Date: 02-Feb-2026
Our Ref: 2025/92676

**Discharge of details reserved by conditions 12 (retaining walls), 17 (carbon emissions), 18 (crime mitigation strategy), 20 (noise assessment), 21 (materials), 23 (boundary treatments) and 32 (delivery noise management plan) of previous permission 2023/91405 for erection of foodstore (Class E) with associated access, parking, servicing area and landscaping
Part of former St Luke's Hospital site, Blackmoorfoot Road, Crosland Moor, Huddersfield, HD4 5RA
Application Number: 2025/92676**

PROPOSED STONE RETAINING WALL WITH ASHLAR STONE CAPPING FINISH (TO STUCTURAL ENGINEER DESIGN AND DETAILS) WITH 1100MM METAL FENCE/GUARDING ON TOP. (RETAINING WALL HEIGHT VARIES)

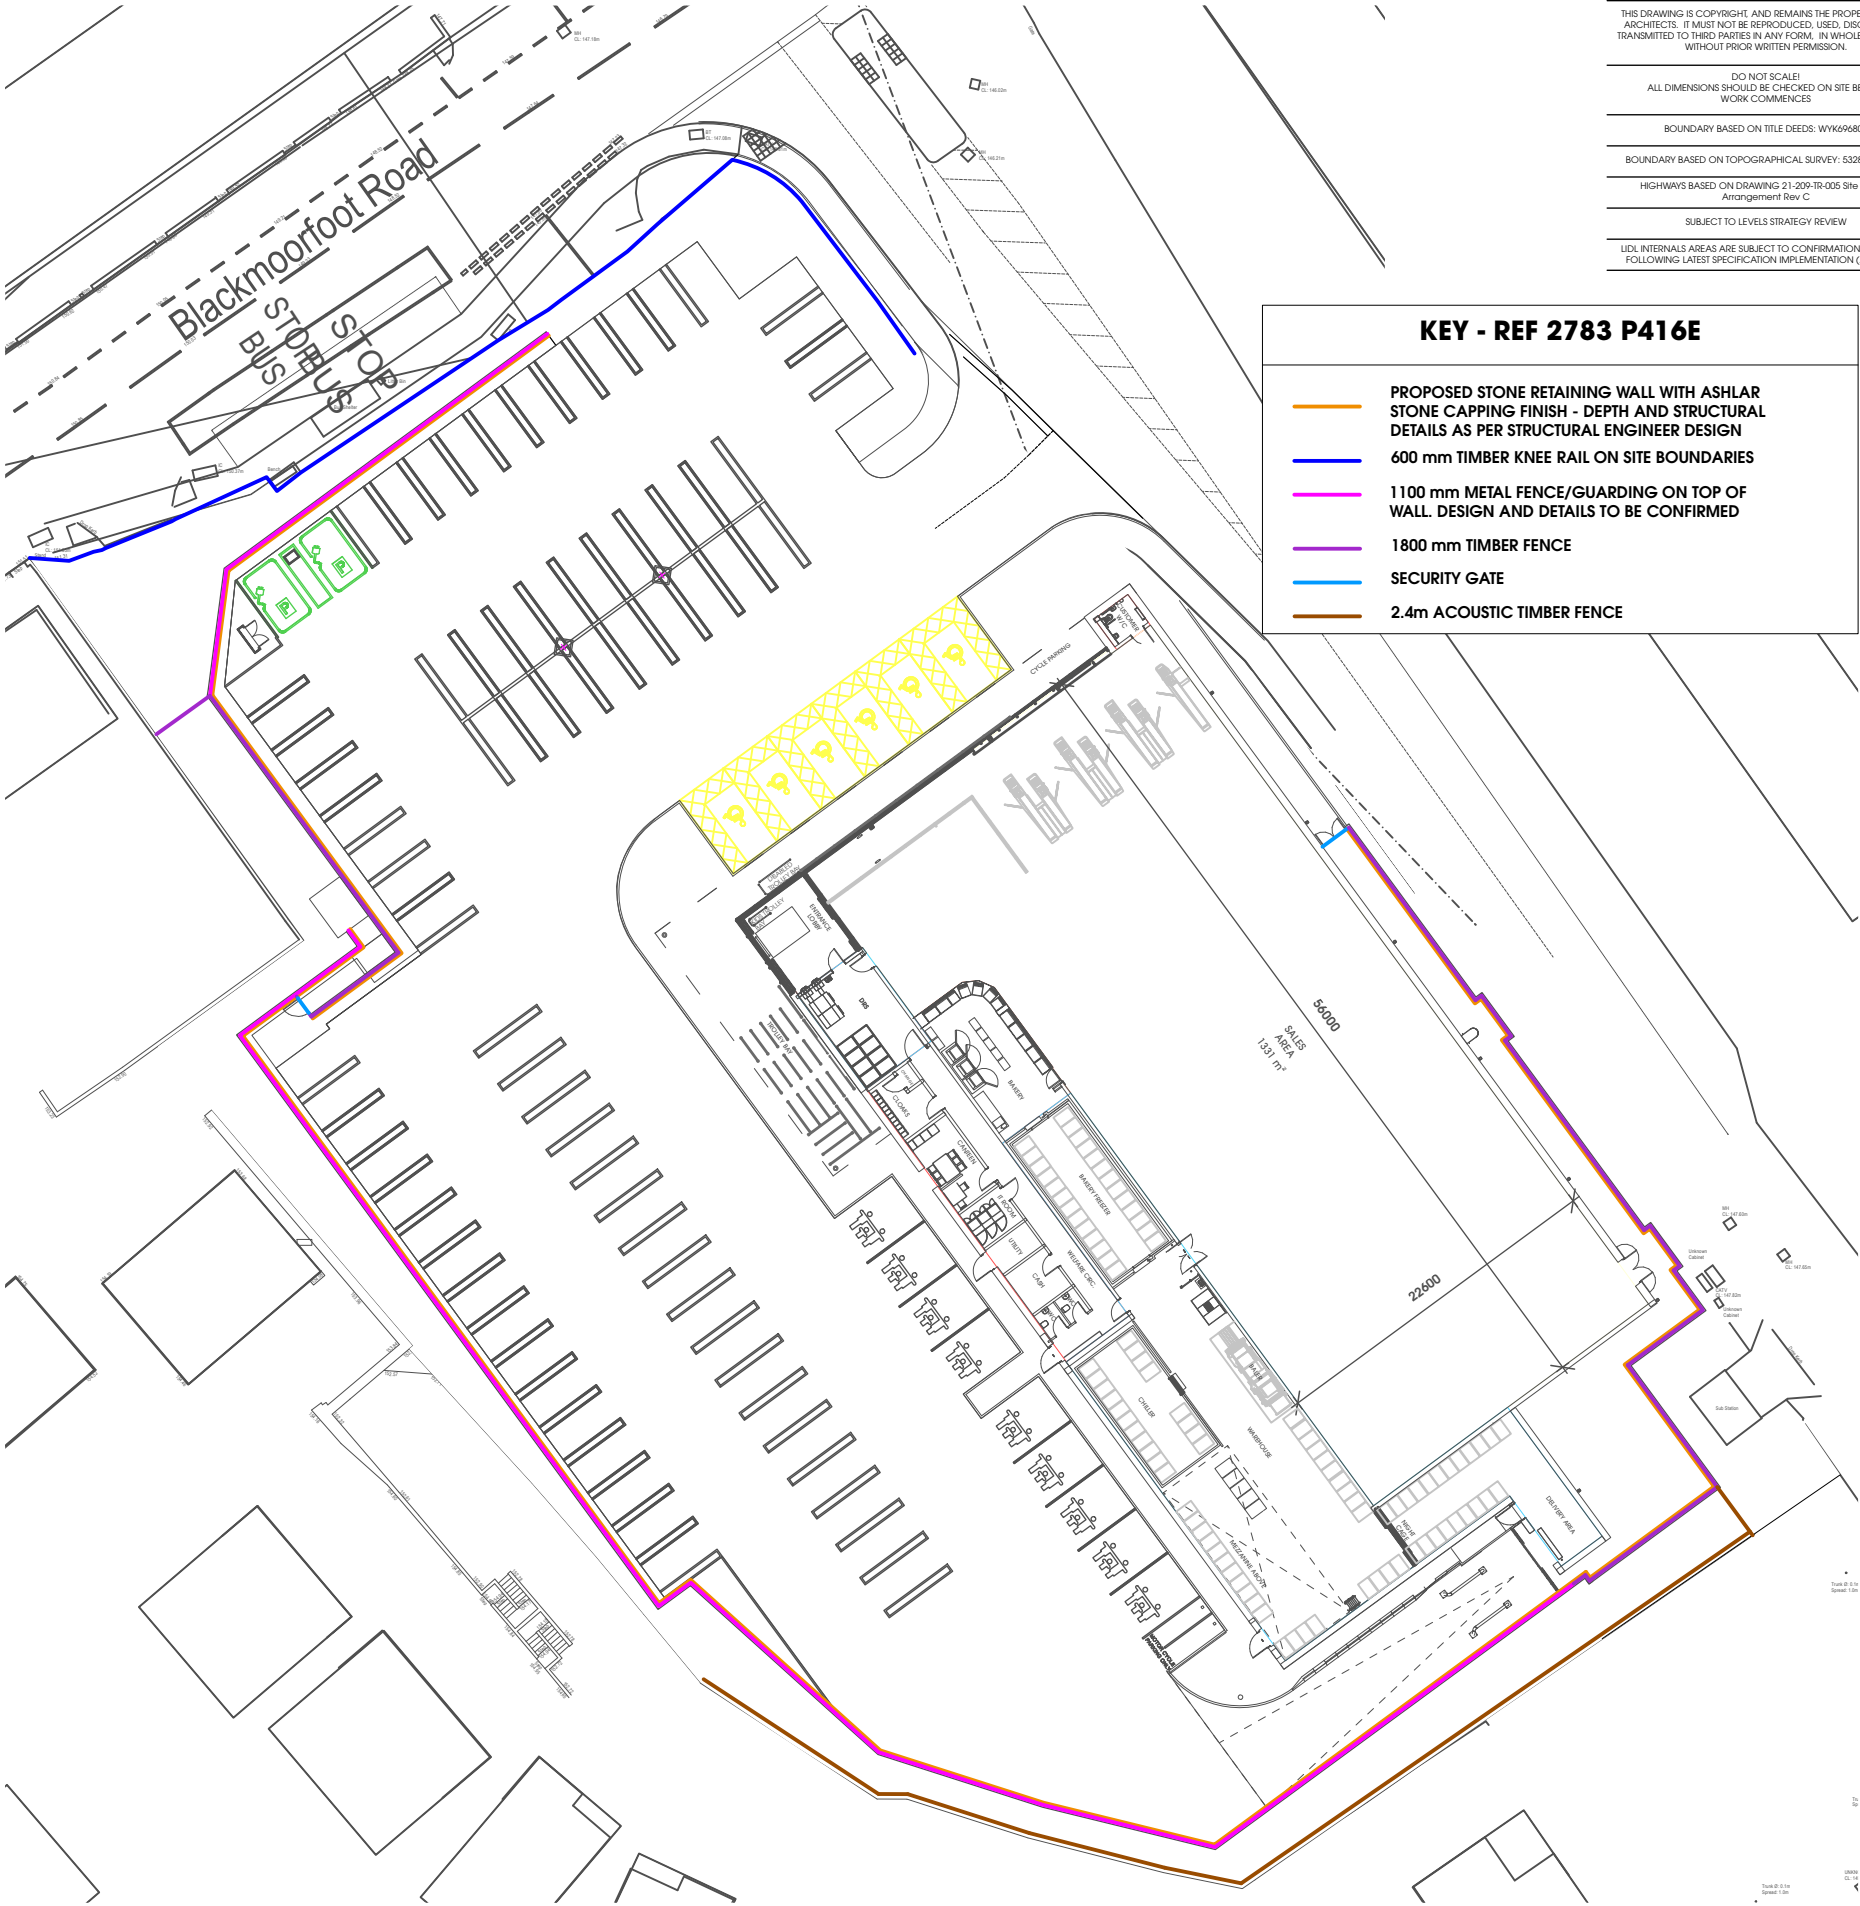
- Proposed Retaining Wall Elevation (reference P503 rev A)

The latest comments from the Highways Structures Team are that the information submitted is insufficient to discharge Condition 12. Therefore, in order to assess the structural integrity of the proposed retaining wall adjacent to the highway, along with its design and materials, a technical report is required.

As such, this condition cannot be discharged at this time.
